AJHajh-20220125-ArunCrem Planning Response_LPA.docx

Y/184/21/DOC – CONDITIONS 8, 9 AND 10: DRAINAGE RESPONSE

Thank you for returning comments from your Drainage Engineer pertaining to planning conditions 8, 9 and 10 under planning permission Y/184/21/DOC for the Crematorium, Bognor.

Hydrobrake chamber (type 1, simple control)  
Scale 1:20

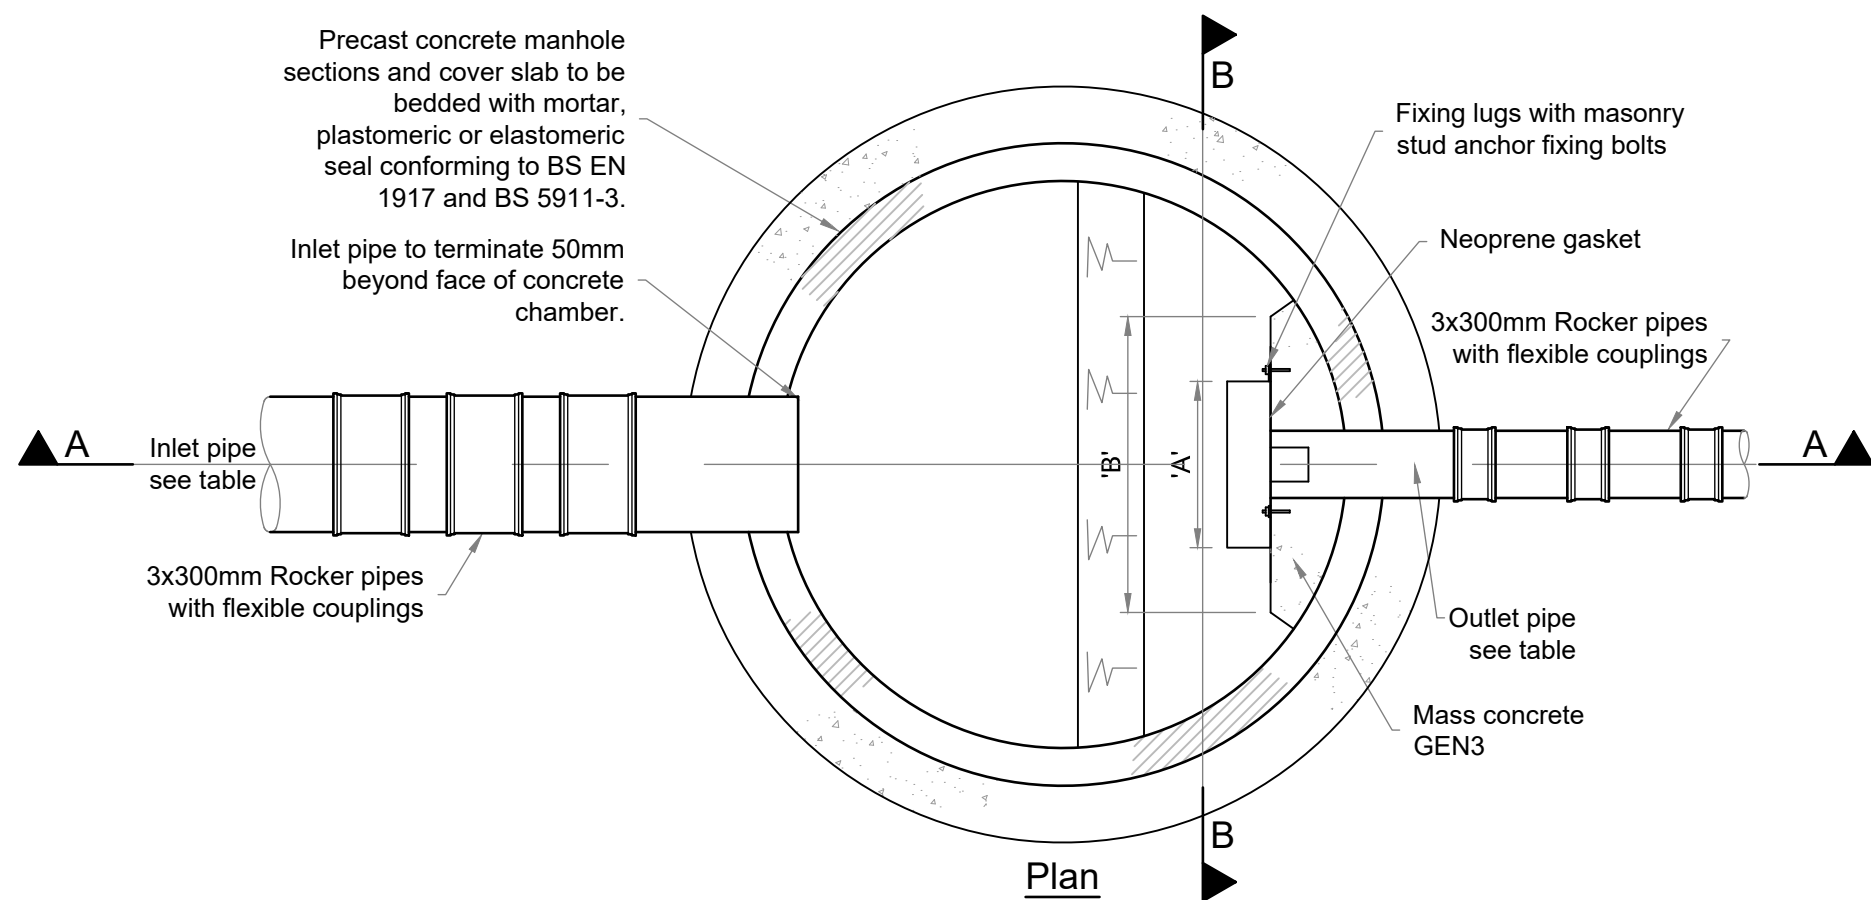
- 1. Please supply results of winter groundwater monitoring and winter infiltration testing.*
- 2. Please supply calculations to support design.*
- 3. Please supply an impermeable area catchment plan.*
- 4. Please label all pipes with diameter and fall.*
- 5. Hydrobrake unit references should be included on layout plans.*
- 6. Please label finish and formation level of permeable paving.*
- 7. Gullies and channel drains should be labelled with cover levels.*
- 8. The gabion outfall construction detail drawing is unclear. Is it proposed to have buried pipes discharging to the basin?*

5. Details have been added to updated drainage layout plan 13591-CRH-XX-XX-DR-C-5051 Revision P5.
6. Permeable pavement details have been previously provided on detail drawing 13591-CRH-XX-XX-DR-C-5350 Revision P2. This includes depths of proposed pavement build-up. The proposed surface levels can

Headwall Outfall to Watercourse

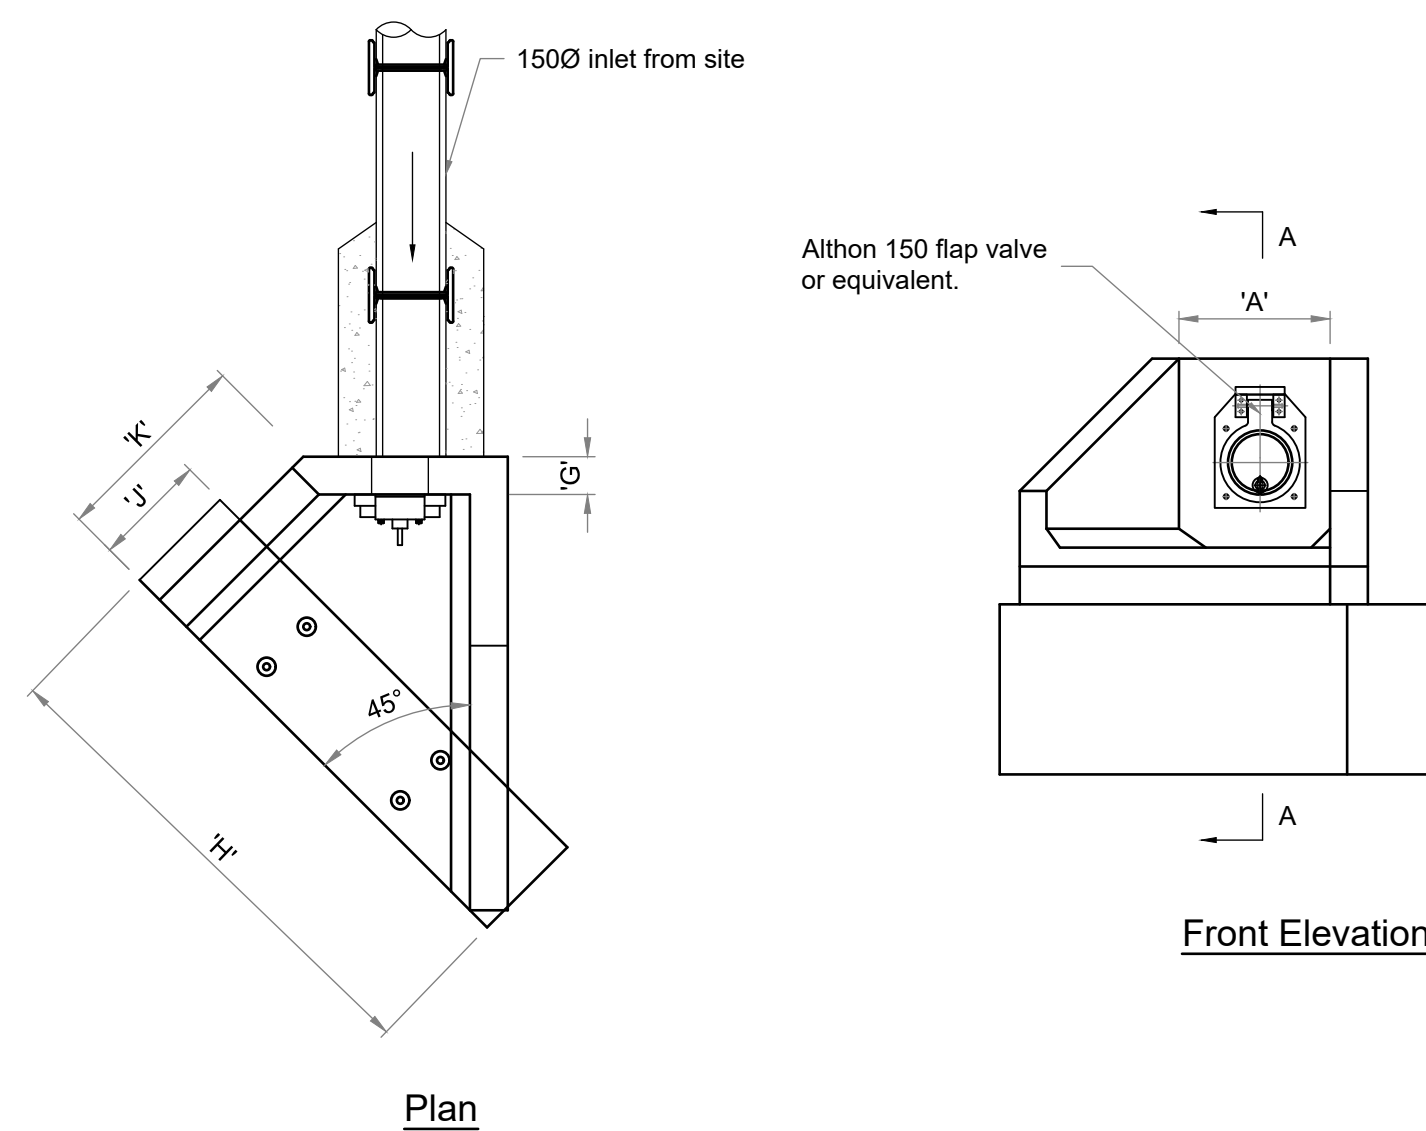
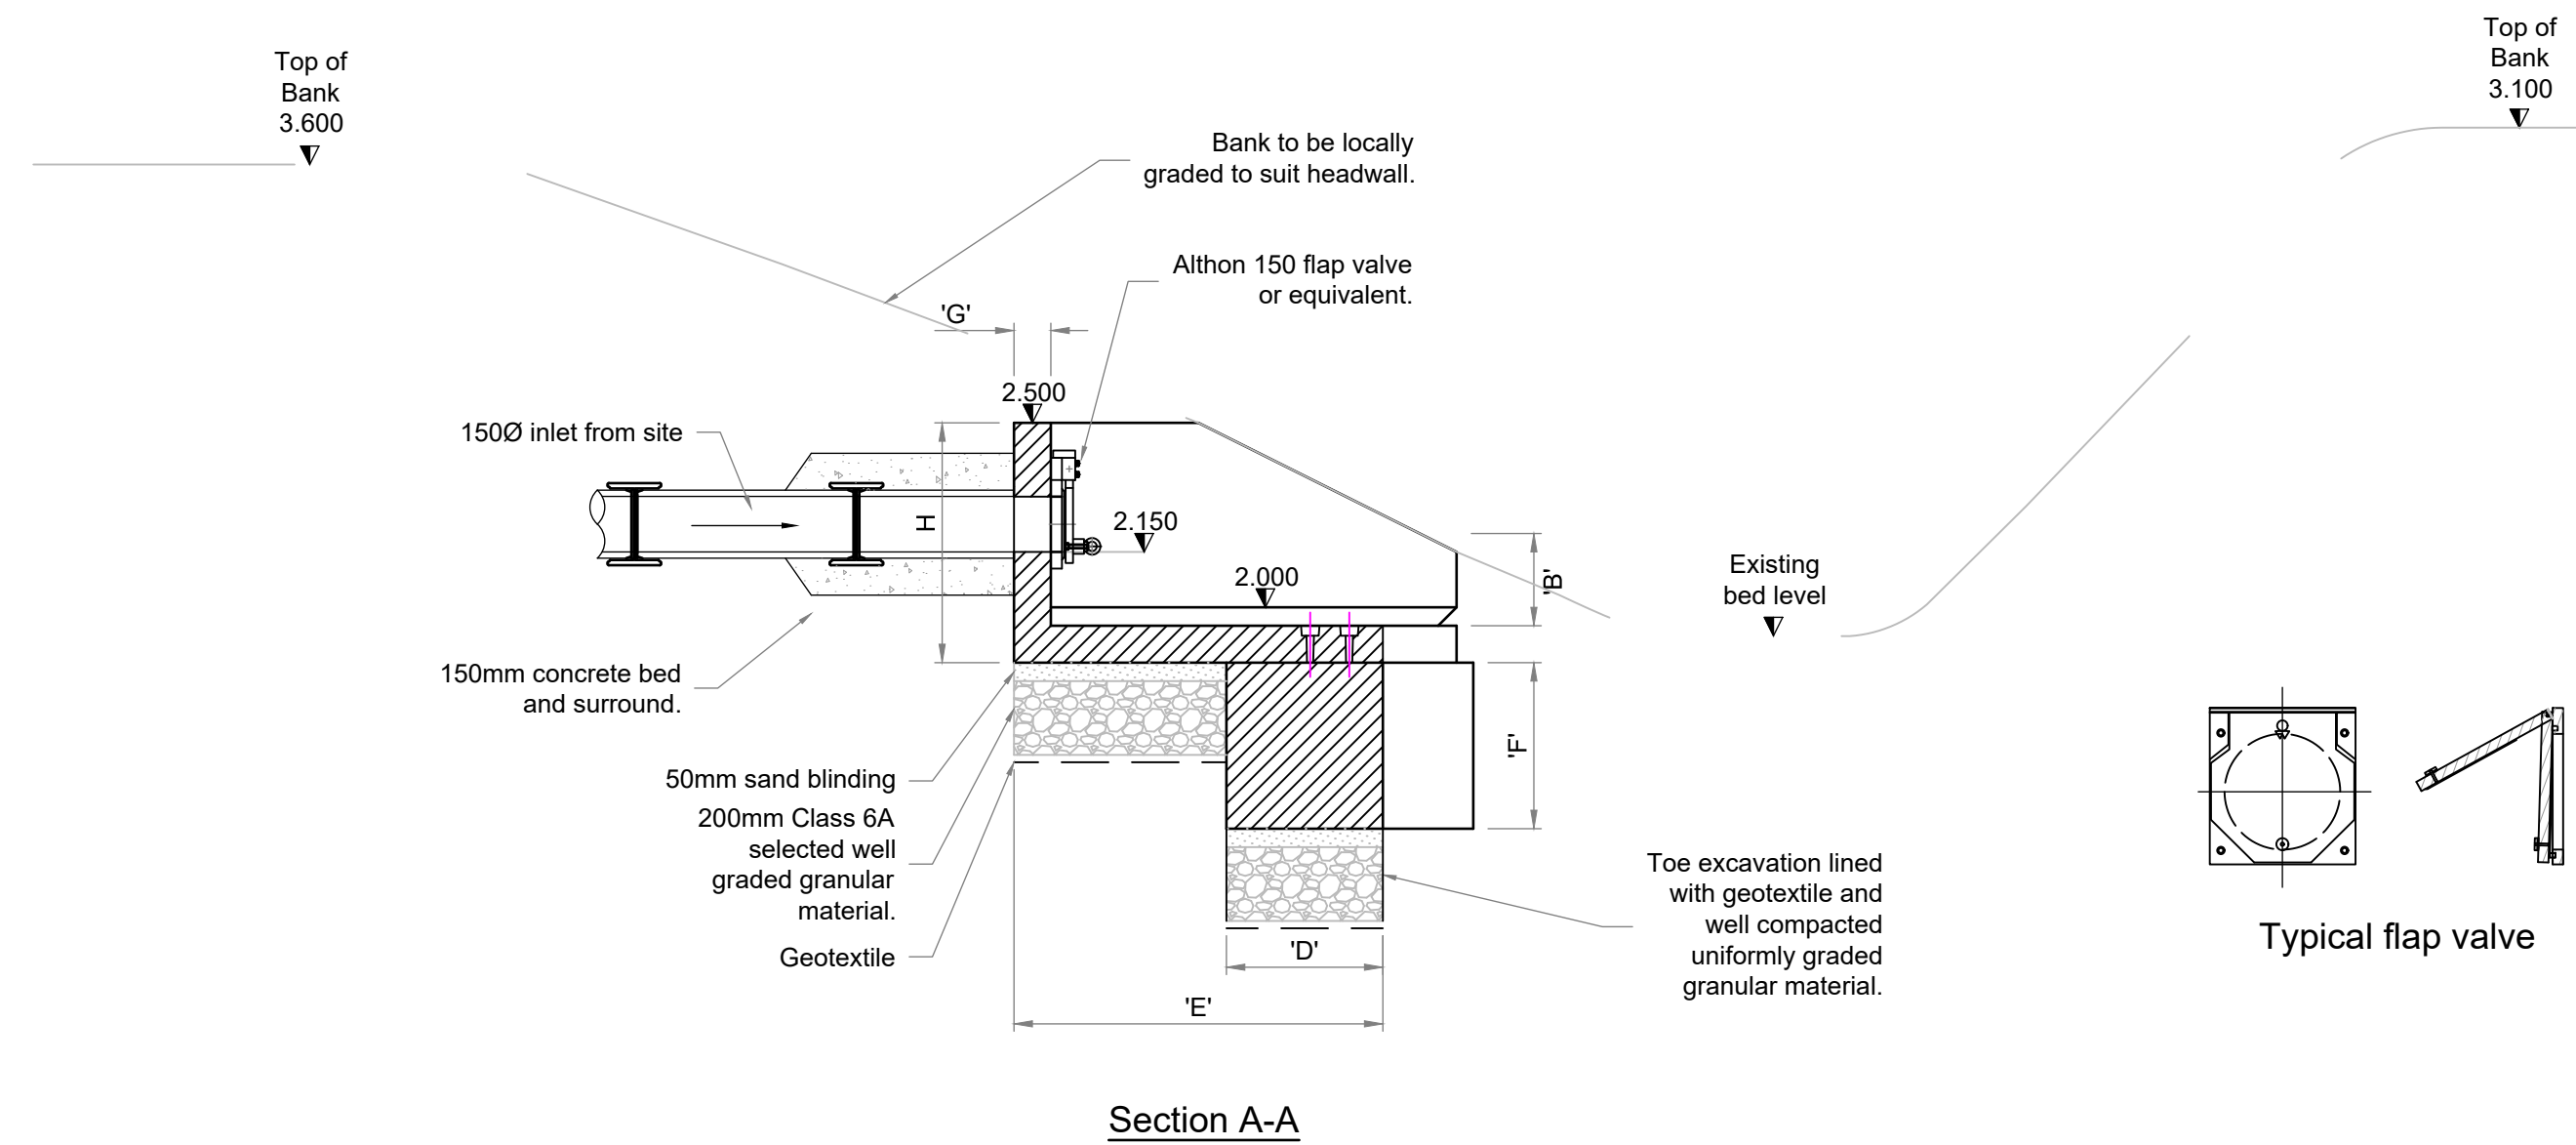
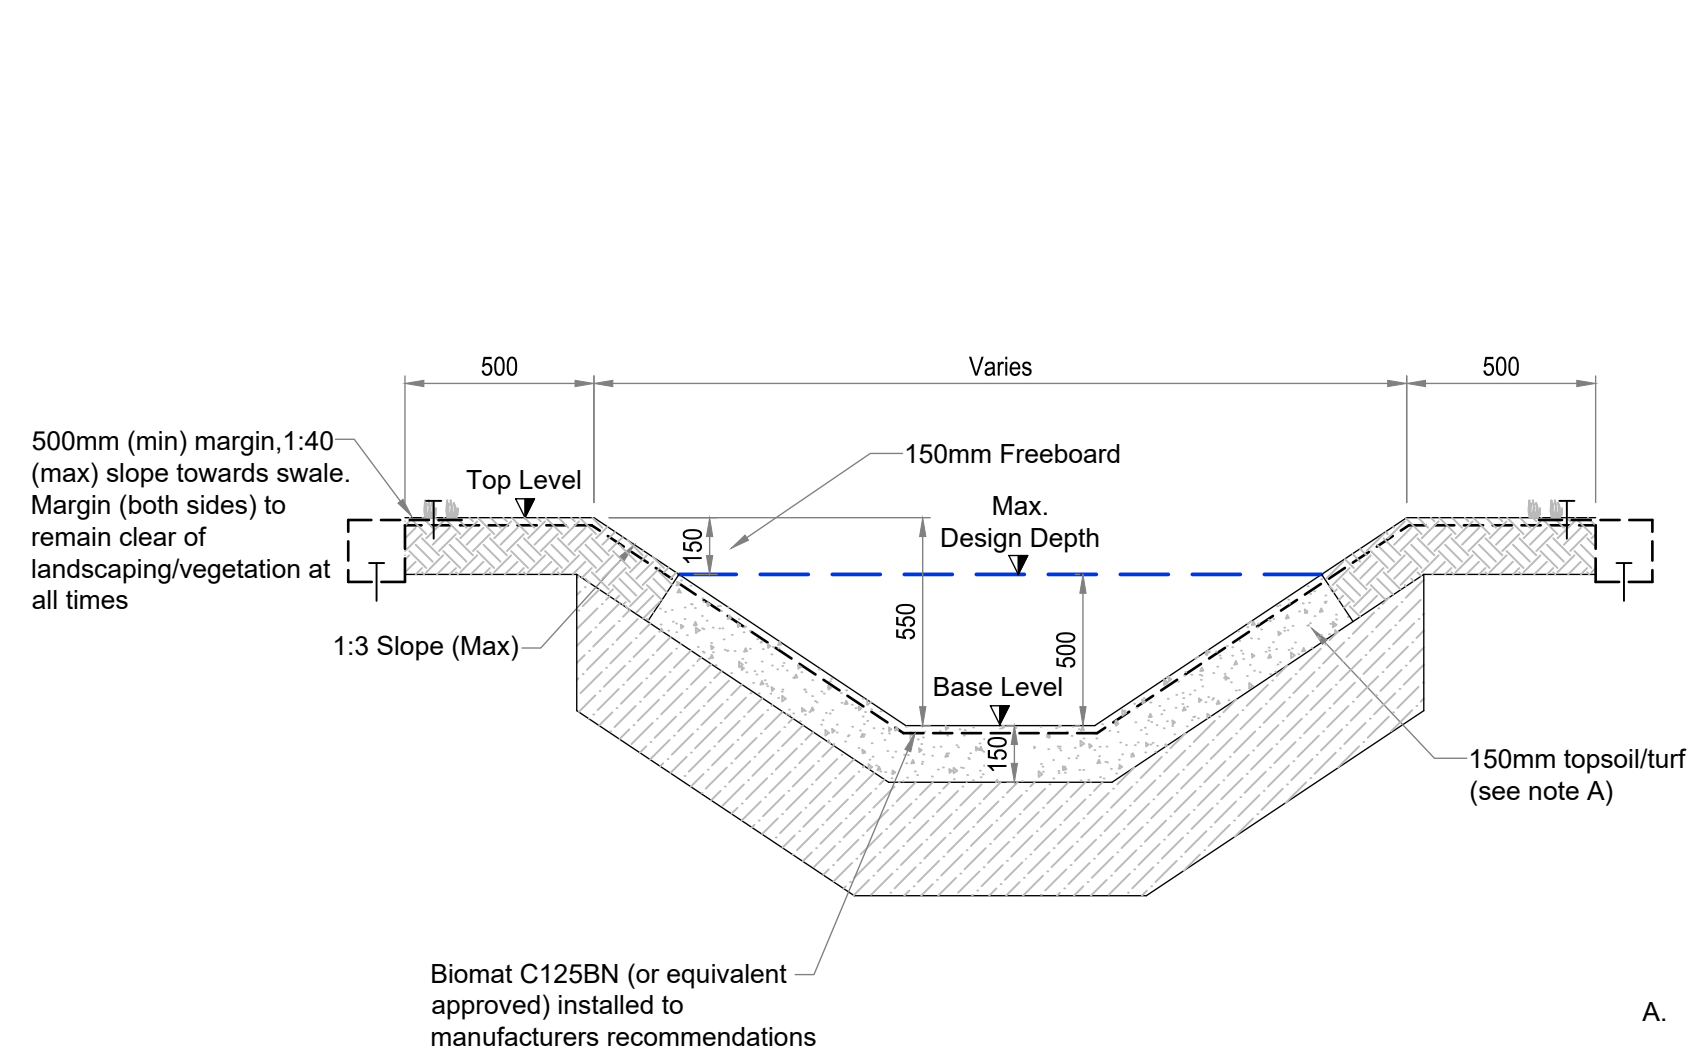
1. Please supply evidence of consent applications for the new ditch, and headwall to the existing ditch.
2. Please supply a buffer plan to show that at least 3m is being provided between top of bank of watercourses and obstructing features, such as fences, buildings, and basins.

1. OWC application for the discharge headwall from the basin was formally submitted in September 2021 together with all information requested by Paul Cann as per his email of 11th August 2021. Referring to Land Drainage Act 1991 Section 23(3), could you please confirm when consent letter will be issued?
2. The OWC consent for the new ditch is as shown on the attached consent (Consent Number LDC/ARUN/2021/015)
3. A suitable buffer has been provided between top of basin and edge of watercourse to allow for maintenance, as shown on drawing *13591-CRH-XX-XX-DR-C-5051 Revision P5*.
